To: FILE
From: Nell Donaldson
Subject: Application ID: 2013-179
Date: 9/19/2013

To: Nell Donaldson
Barbara Barhydt
From: David Margolis-Pineo
Re: Review Comments – Bayhouse II – 40 Hancock Street

The Department of Public Services has the following preliminary review comments for the above mentioned project.

PRECAST CONCRETE CATCH BASIN - TYPE "E"
NOT TO SCALE

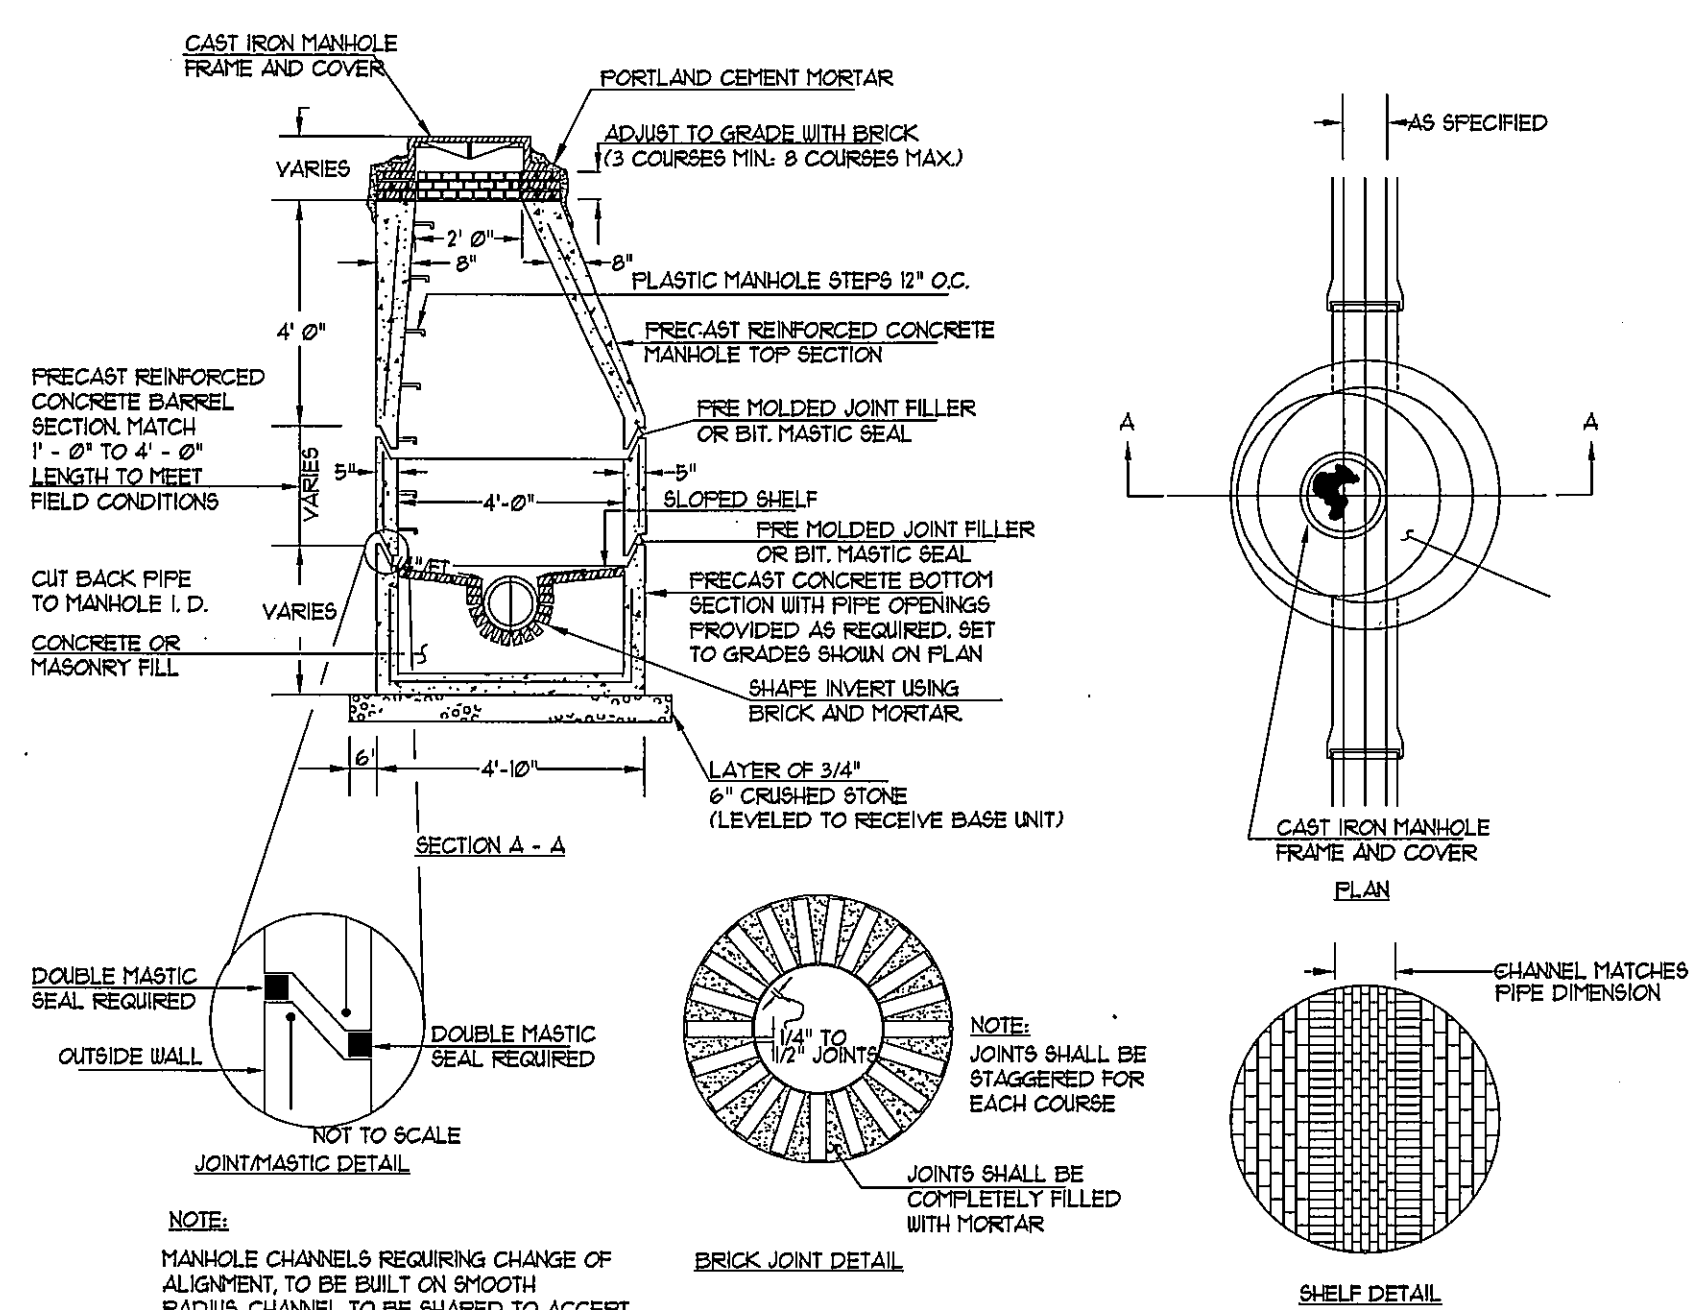
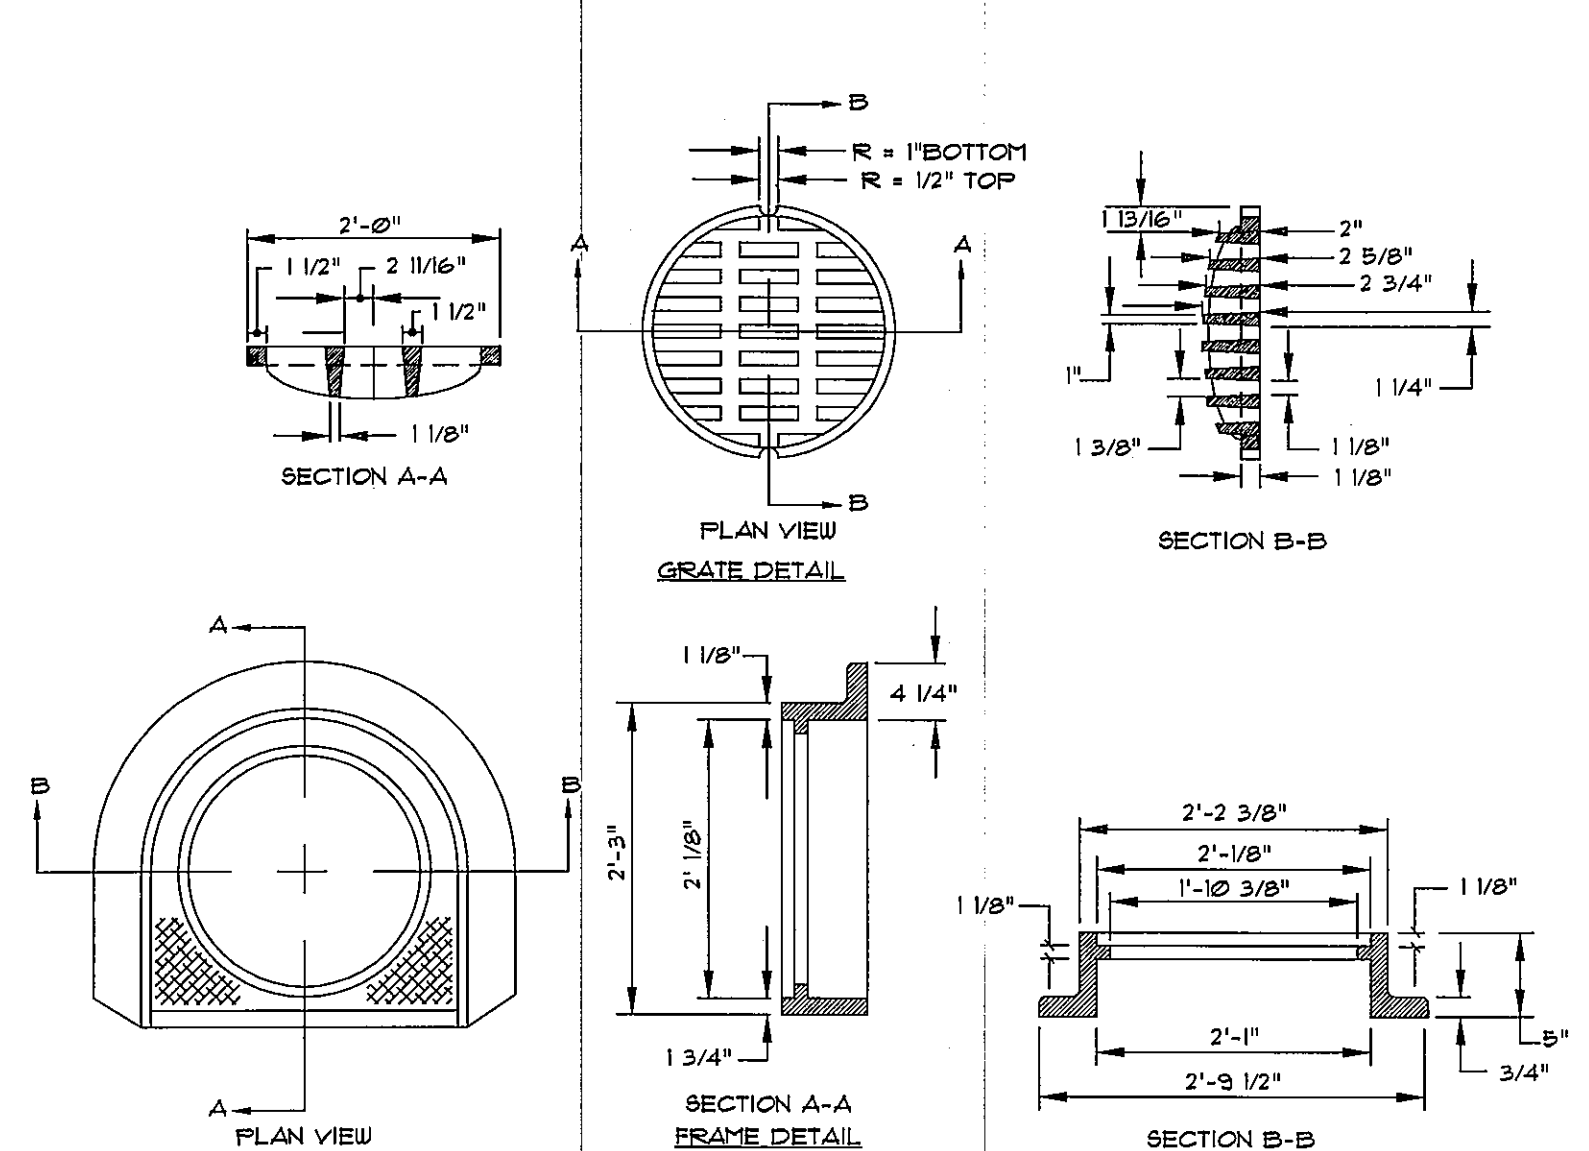
2. All catchbasins proposed for this project will have "The Snout" or approved equal install on the outlet pipe. Note on plans now indicates the use of the Snout. However the catchbasin detail does not show or indicate a three foot sump, the City's standard. It is understood that referencing the City's Tech Standards will address this. No further comment.
Note #5 on Sheet 12 of 14 should be changed to reflect that a three foot catchbasin sump is required. This should be done prior to the pre-construction conference and re-submittal is not required.
